Date: 15<sup>th</sup> June 2022

Our Ref: 14/351

**Re: Epiq Lennox (Pacific Pines Estate), Lennox Head - MP 07\_0026 MOD 7**  
**Response to Submissions & Additional Information**

DRAWING No.
140351-S5-DA-CI-01

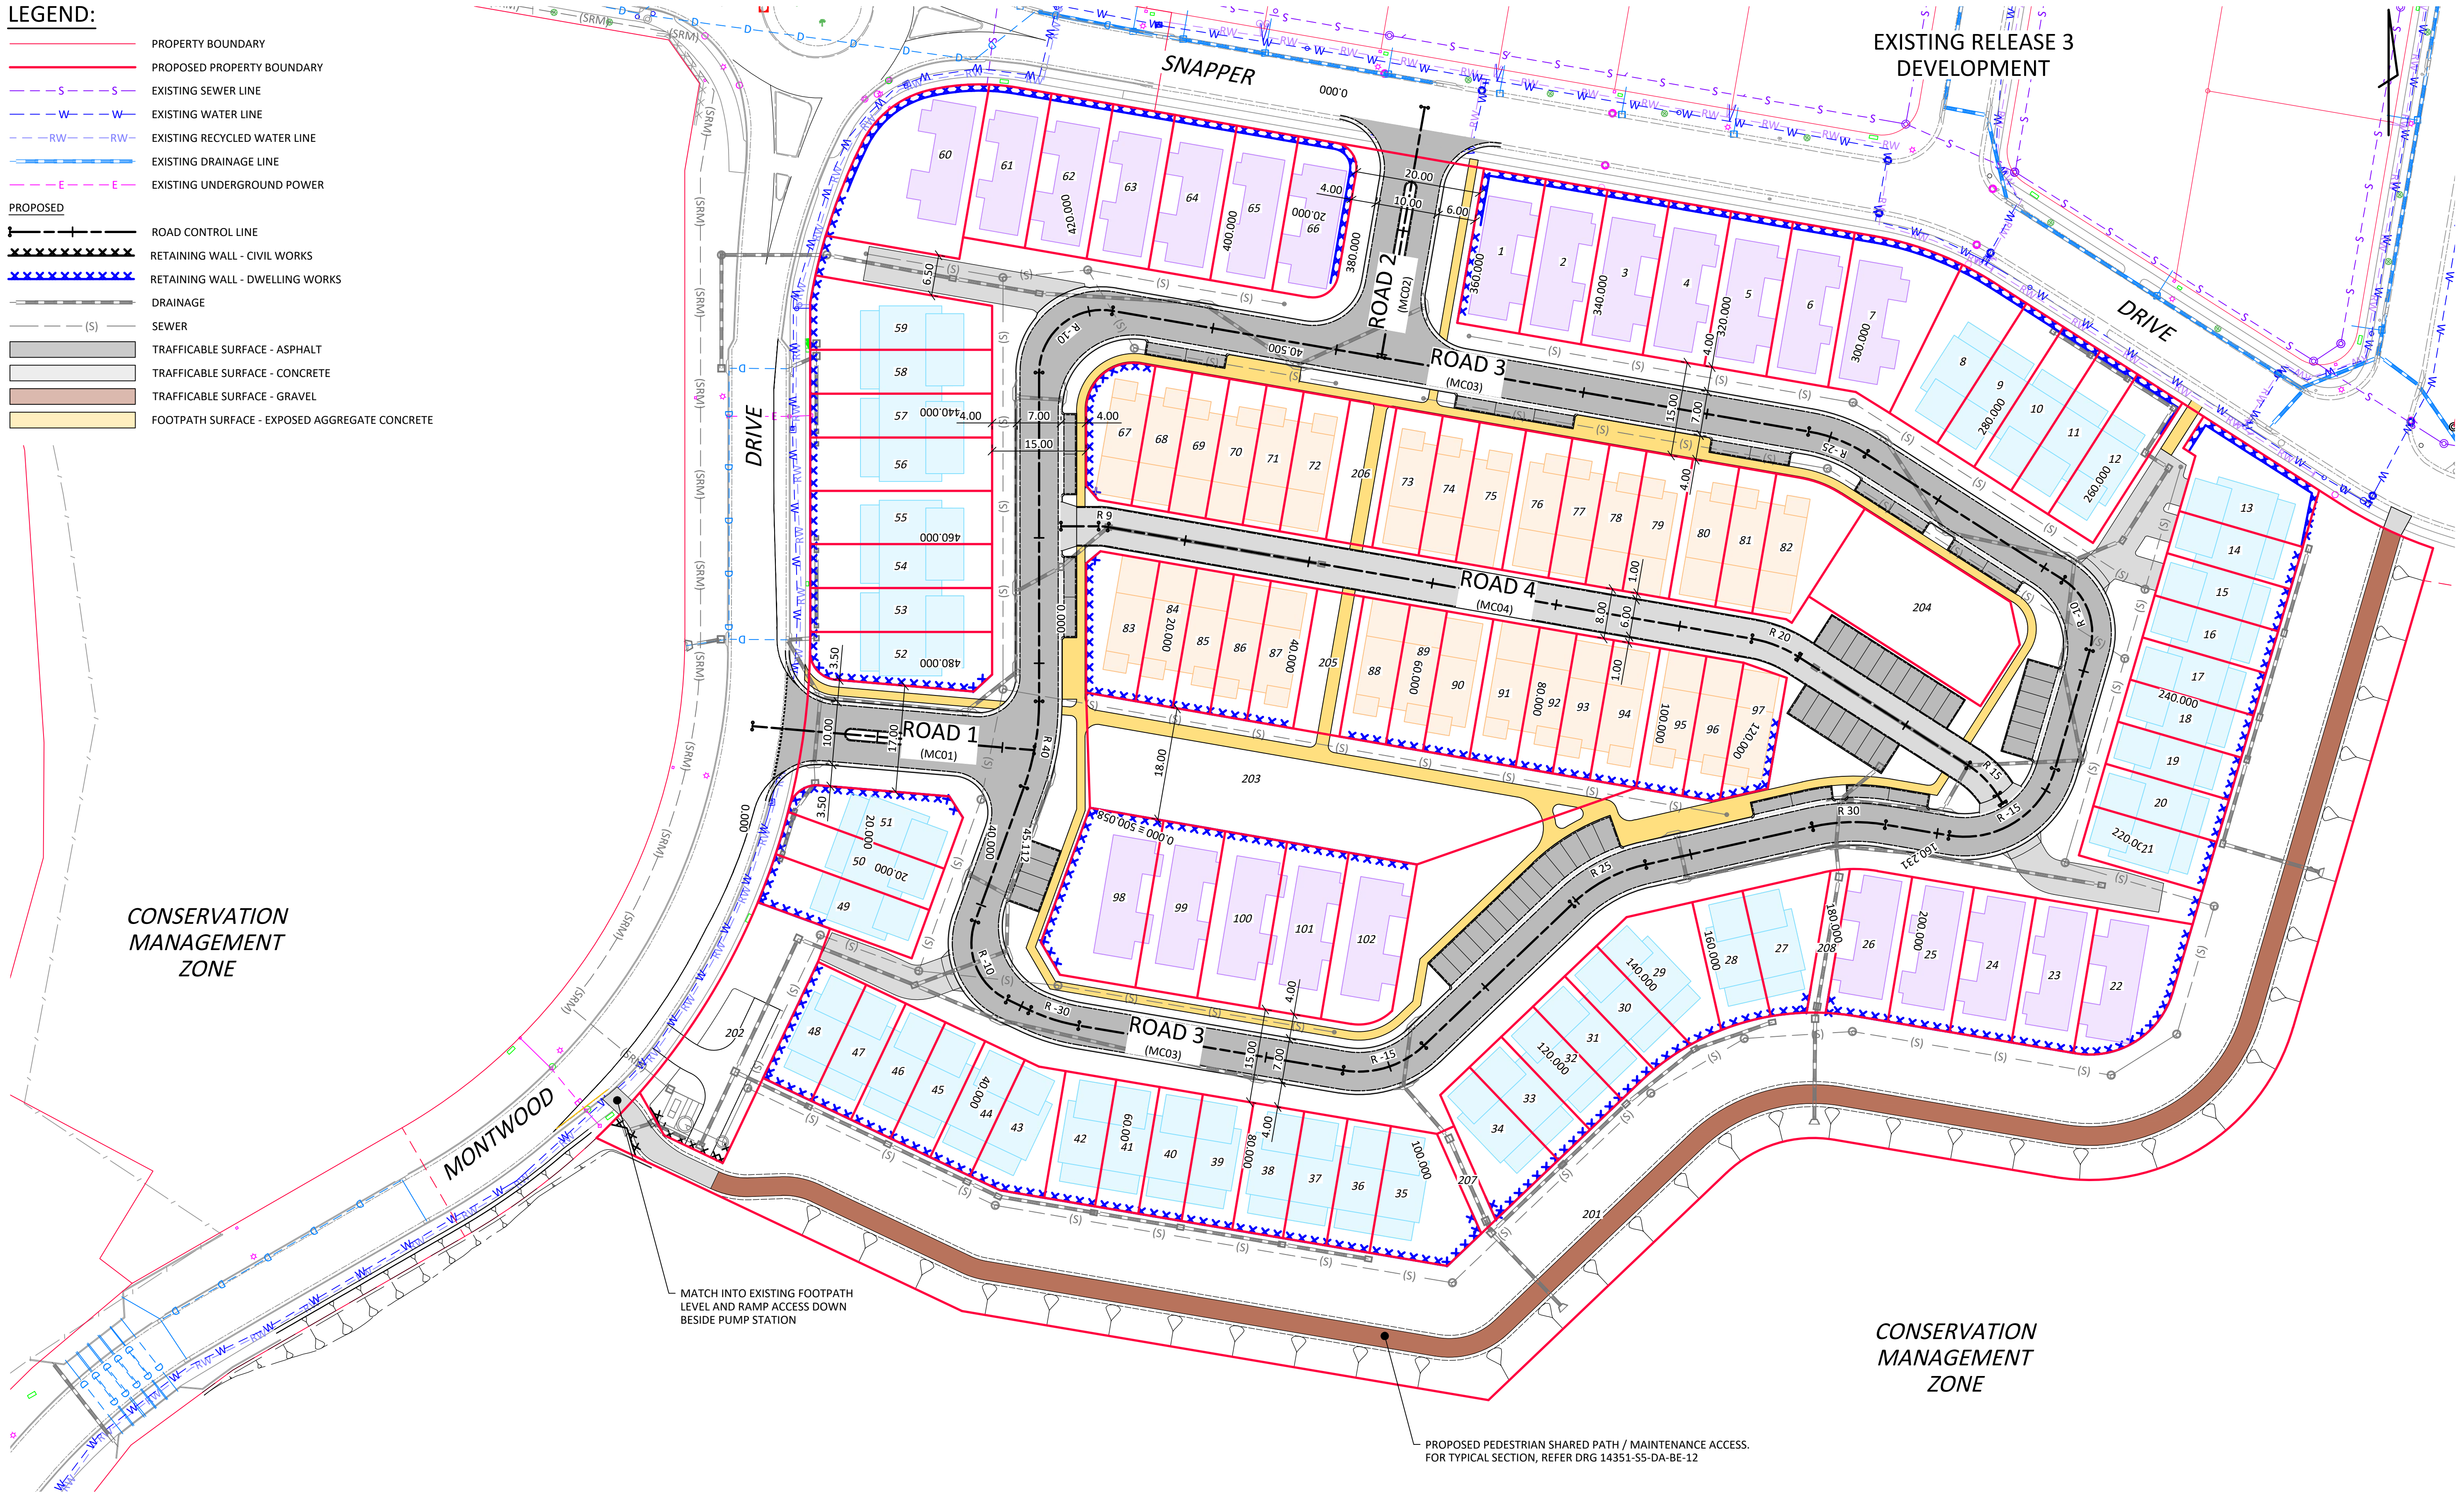
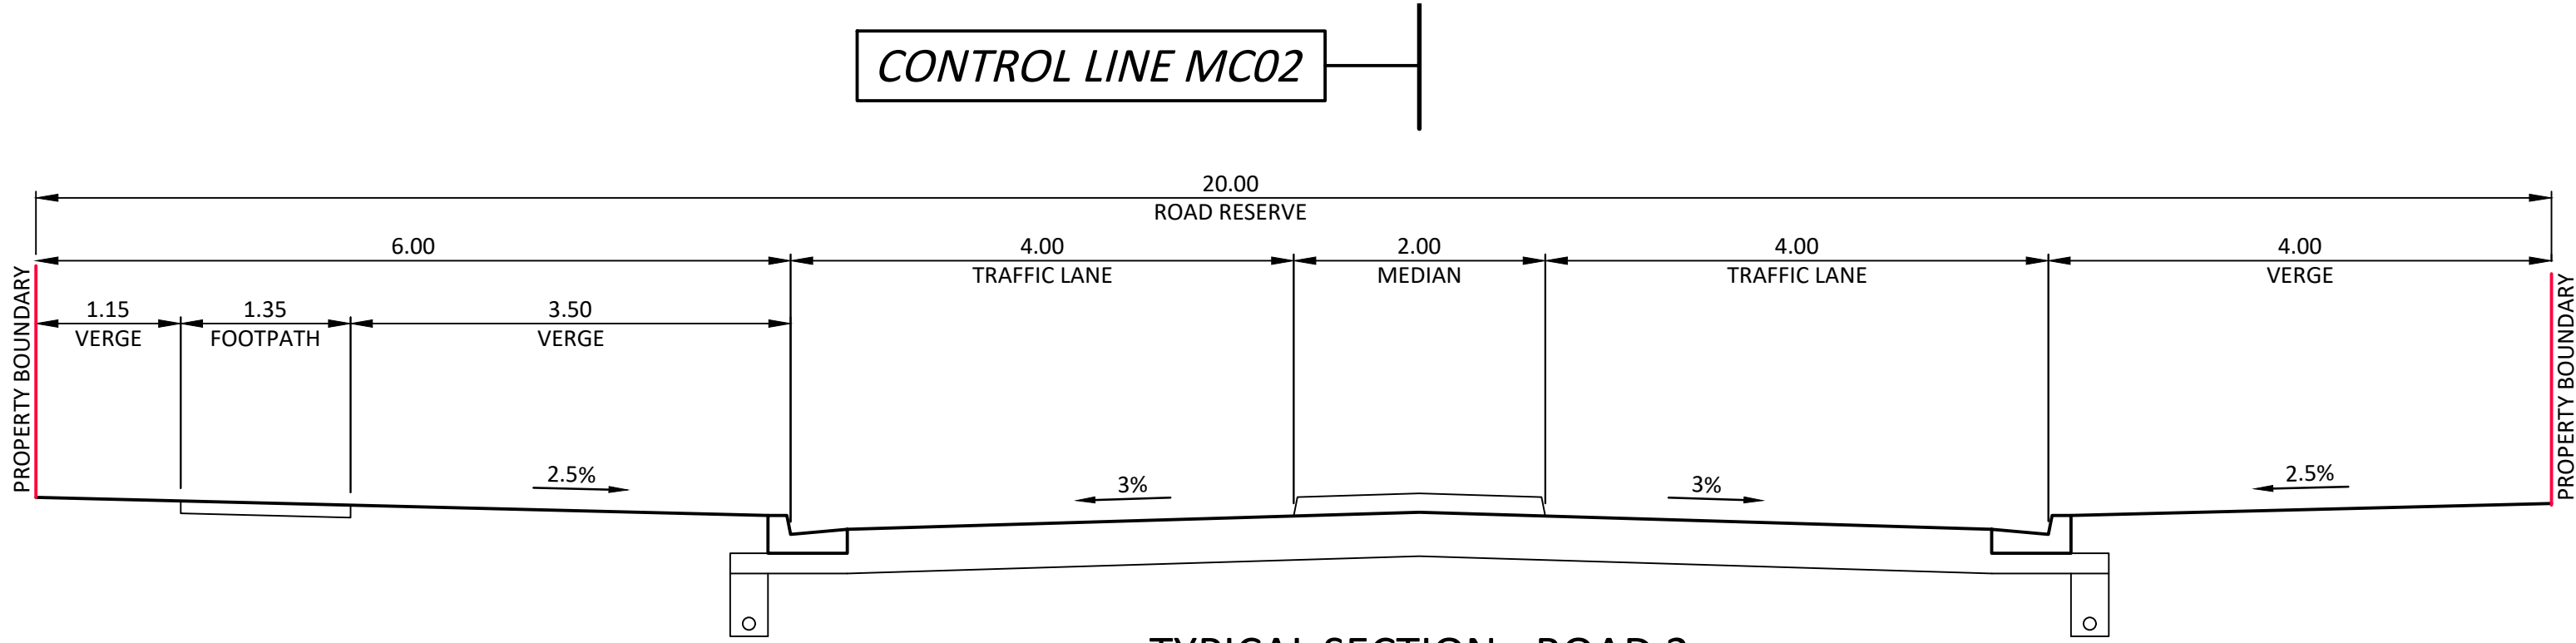
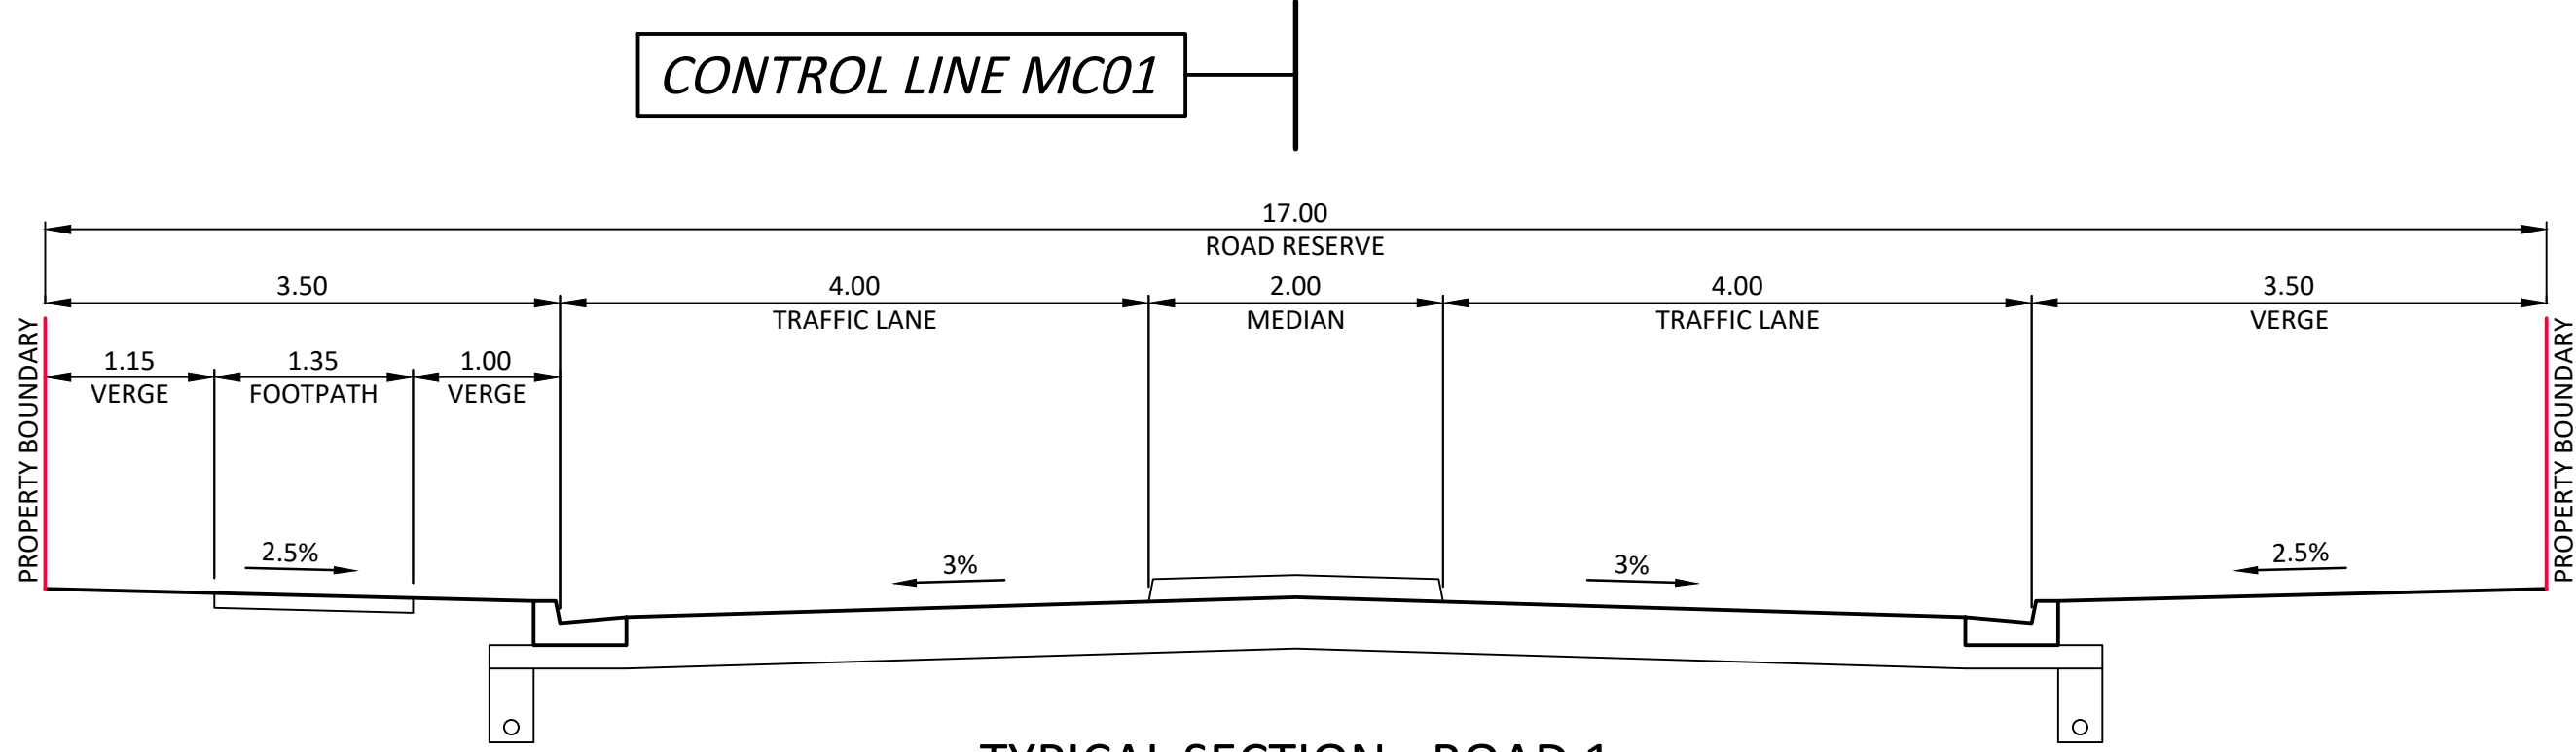
6. *Clarification whether the 3m shared access gravel footpath/cycleway is sufficient for emergency service access noting the NSW Rural Fire Service (RFS) comments dated 23 July 2020 identified the need for a minimum 4m accessway (along with other accessway requirements) and that correspondence from Bushfire Certifiers (dated 7 February 2022) indicates acceptance of the RFS comments.*

**Comment:** Reference is made to NDC Plan 140351-S5-DA-CI-01 (Rev C) (**Attachment 3**) which identifies the footpath/cycleway as being 4m wide and therefore compliant with NSW Rural Fire Service (RFS) comments dated 23 July 2020 which identifies the need for a minimum 4m accessway.
